Homestead North Filing No. 3
Traffic Impact Study
(LSC #S224250)
June 17, 2022

LSC Responses to TIS Redline Comments

Figure 4
Existing Traffic
Homestead North Filing 3 (LSC #S224250)

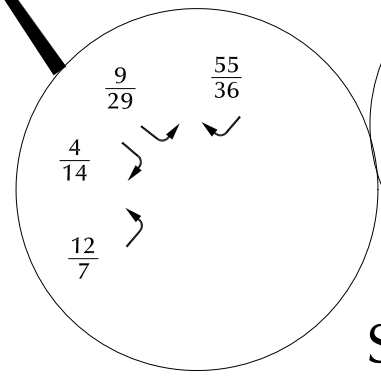
1 PM counts do not match those shown in appendix. Please update

[PM counts do not match those shown in appendix. Please update](#)

LSC Response: The volumes shown on this figure are correct. An incorrect Peak Hour Analysis technical report was inadvertently included in the appendix. This page has been replaced with a correct Peak Hour Analysis in the appendix of the revised TIS.

Figure 6
2042 Background Traffic
 Homestead North Filing 3 (LSC #S224250)

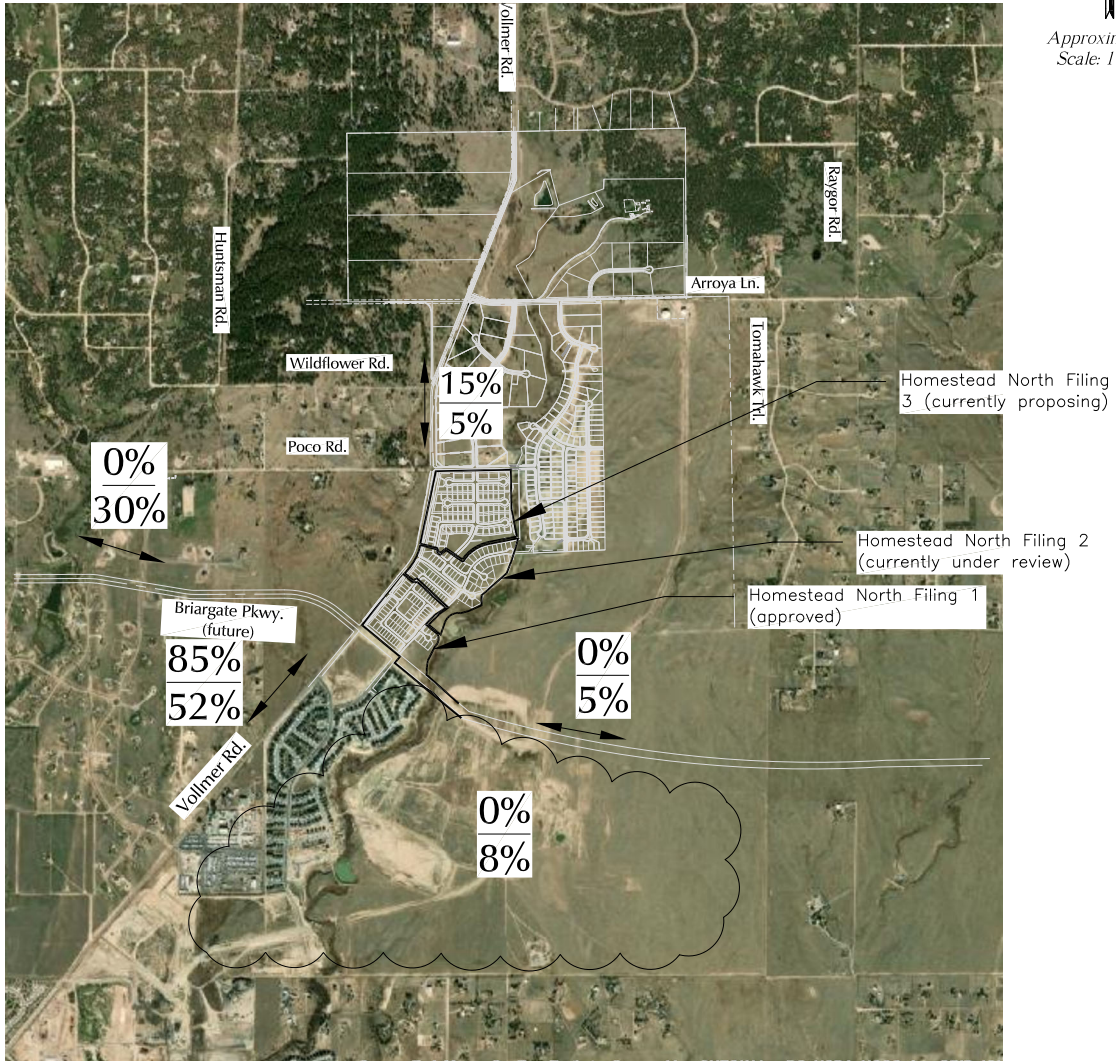
1 Some counts (highlighted) do not match those shown in appendix. Please update

8040 per report. Please revise

[Some counts \(highlighted\) do not match those shown in appendix. Please update](#)

[2040 per report. Please revise](#)

LSC Response: The volumes shown on Figure 6 have been revised and are now consistent with the LOS reports.

LSC Response: The text has been revised to indicate the long term year studies is 2042

Figure 10
Short-Term Total Traffic
 Homestead North Filing 3 (LSC #S224250)

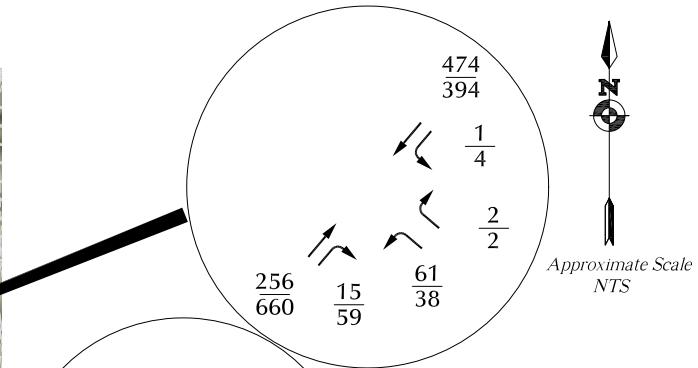
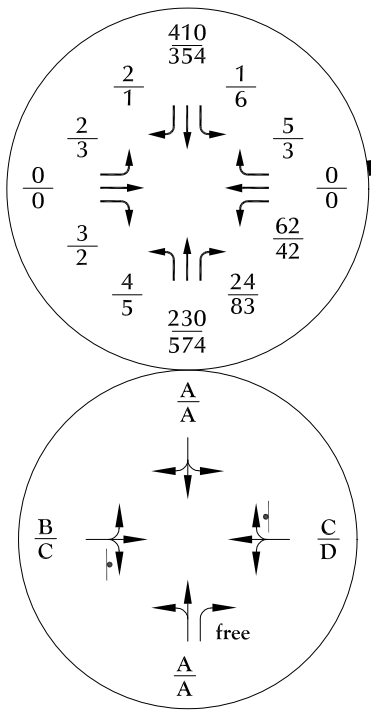
[PM counts for this intersection missing in appendix. Please provide](#)

[PM count for these 3 intersections do not match information in appendix. Please update](#)

LSC Response: The Short-Term Total PM Peak Hour LOS report has been included in the updated TIS

LSC Response: Updated Short-Term LOS reports have been included in the updated TIS that are consistent with the volumes shown in Figure 10
